Y/72/20/RES

Land at Stakers Farm North End Road Yapton

Approval of reserved matters following outline approval Y/44/17/OUT for the erection of 70 No. dwellings, public open space, play area, drainage & landscaping

REV	DESCRIPTION	DATE	AUTHOR	CHECKD
CLIENT				
dandara new homes				
PROJECT				
LAND AT NORTH END ROAD YAPTON				
DRAWING				
BOUNDARY TREATMENT LAYOUT 70 UNIT SCHEME				
SCALE 1:500 @ A1		DATE 02.08.19	AUTHOR LAH	CHECKED -
JOB NO 102-70		DRAWING NO PL-07	REV -	REV -
BRIMSTONE DESIGN LTD

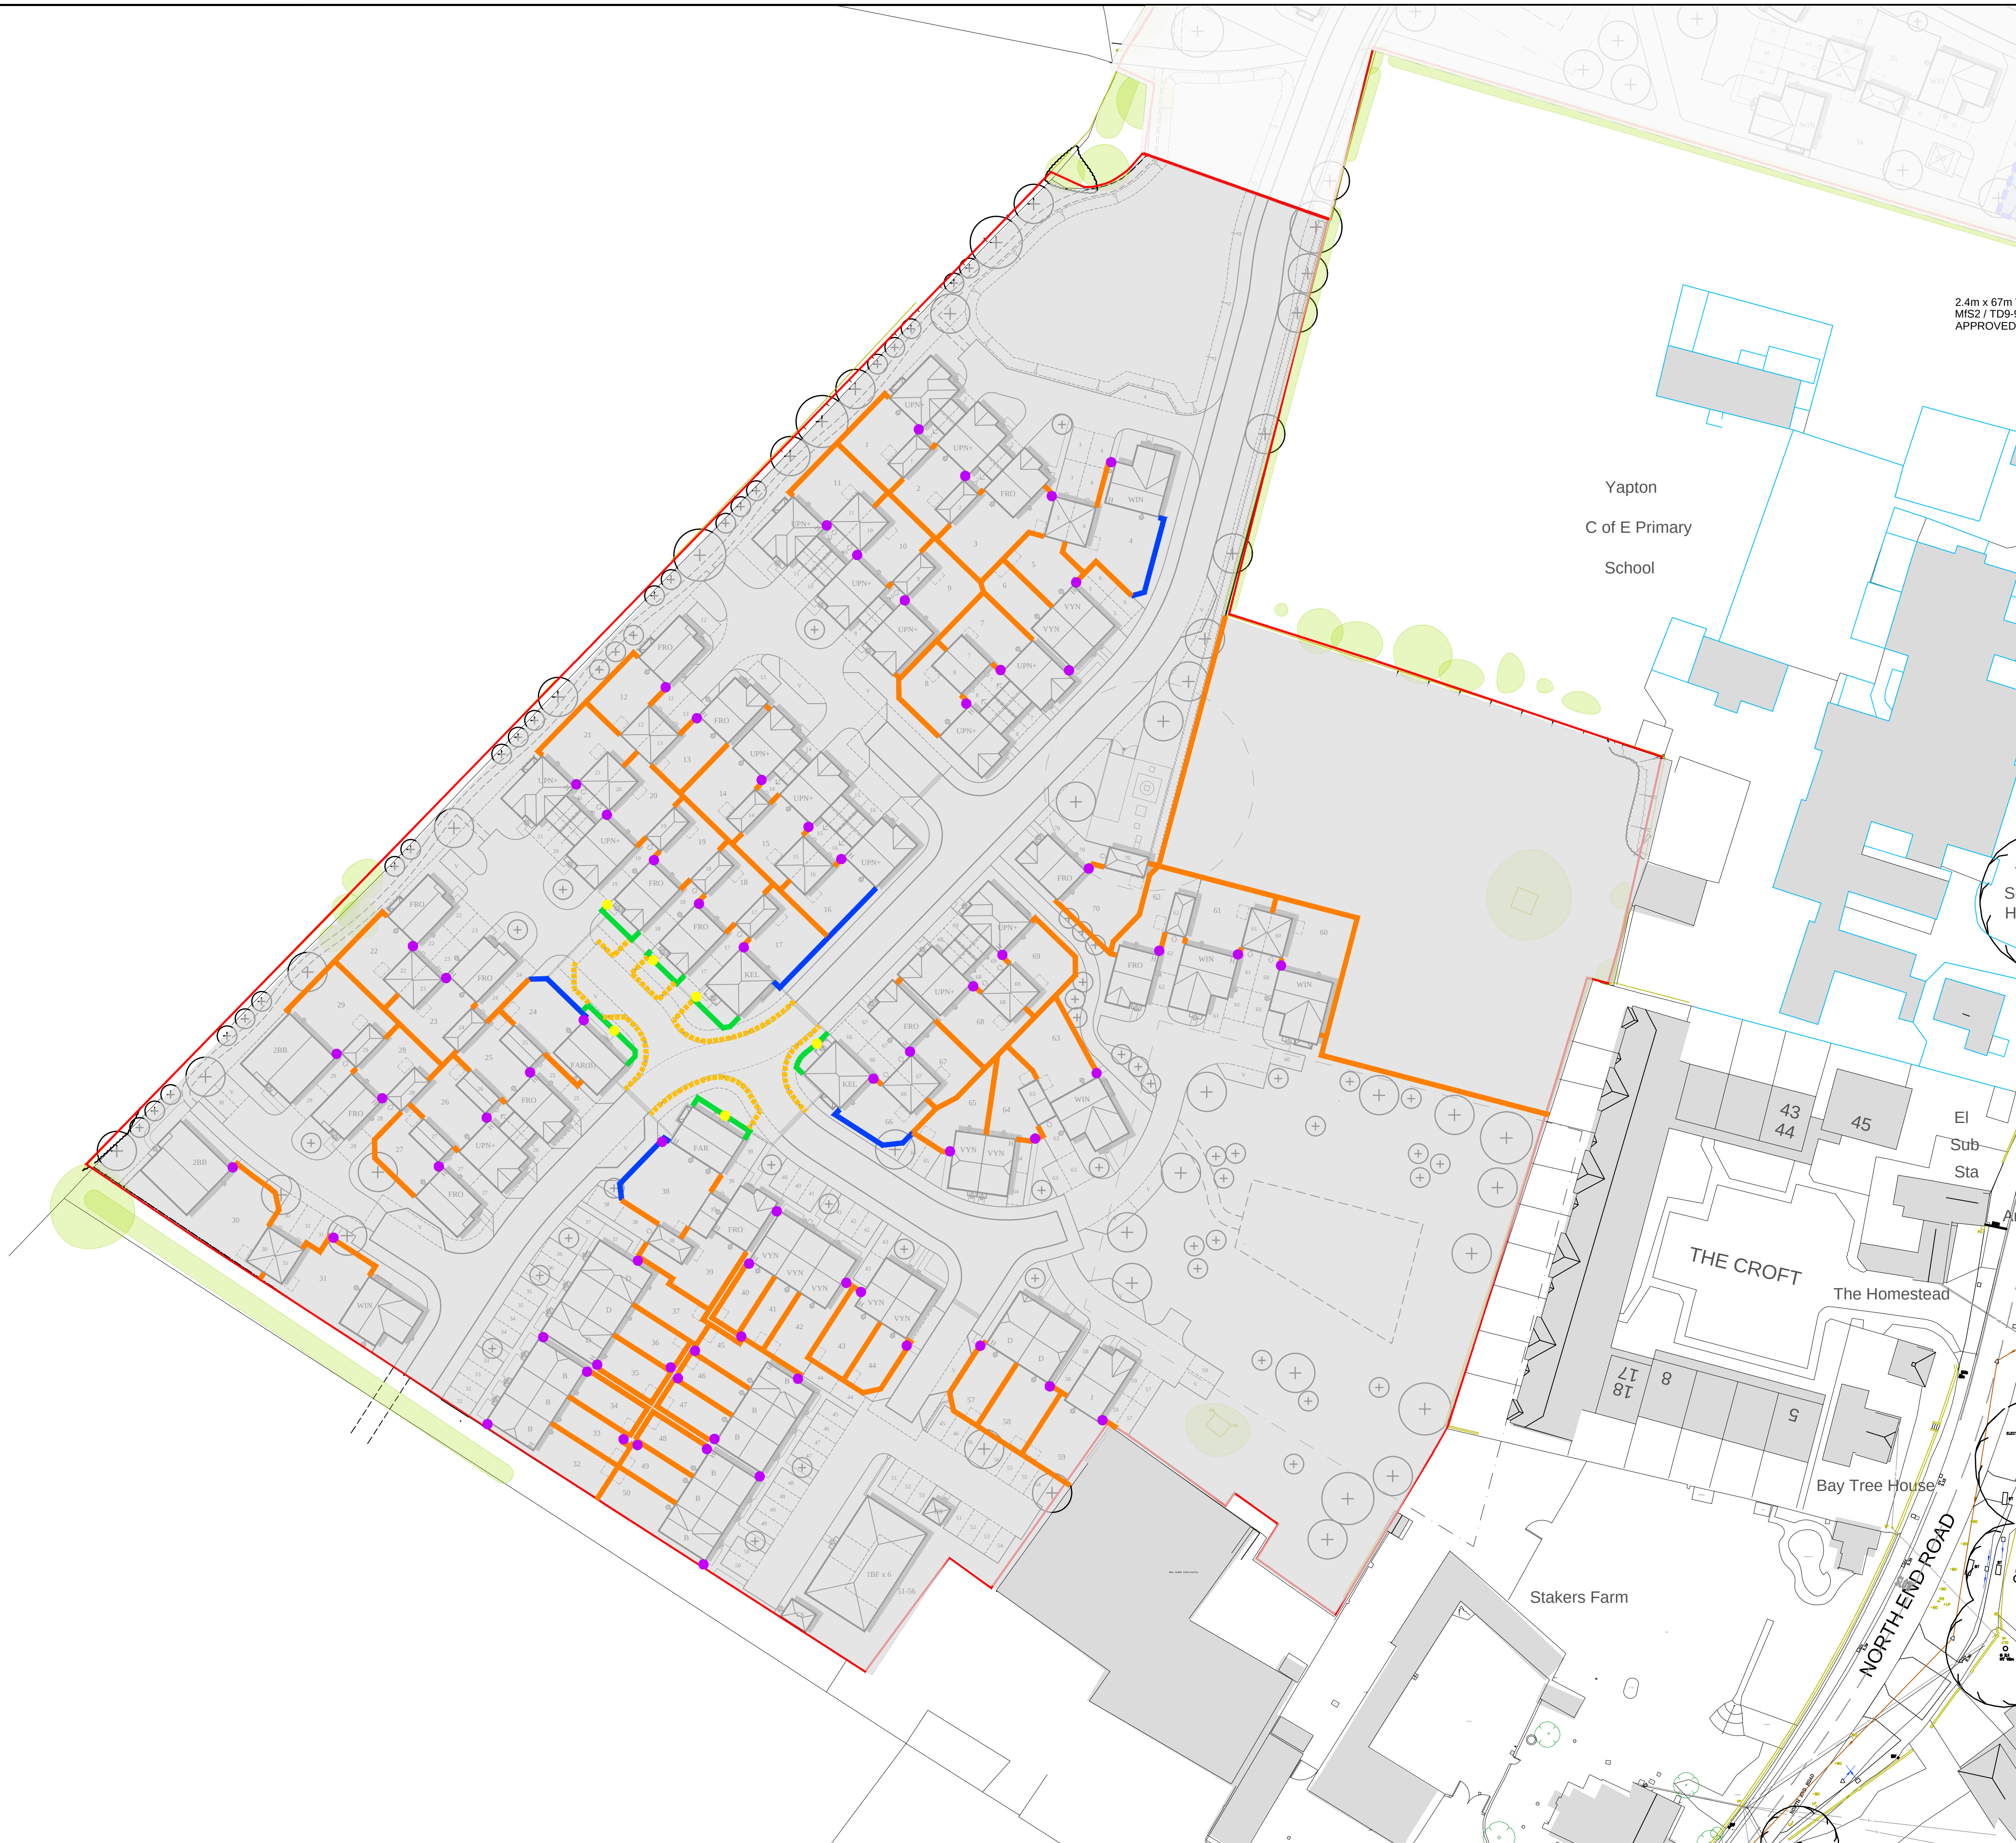
I note that revised plans have been submitted on the proposed scheme. The main point to note from a conservation perspective is the fact that a 1.2 metre wall is to be provided to complete the boundary between the site and the neighbouring property (Stakers Farm). This addition is supported as it will ensure that there is a clear boundary between the listed/curtilage listed buildings and this new development. If minded to approve the application I would want to ensure that the wall is appropriate for the grounds of a listed building. As a consequence, you may wish to request details of the materials (brick) and the proposed bond, should you be minded to approve the application.
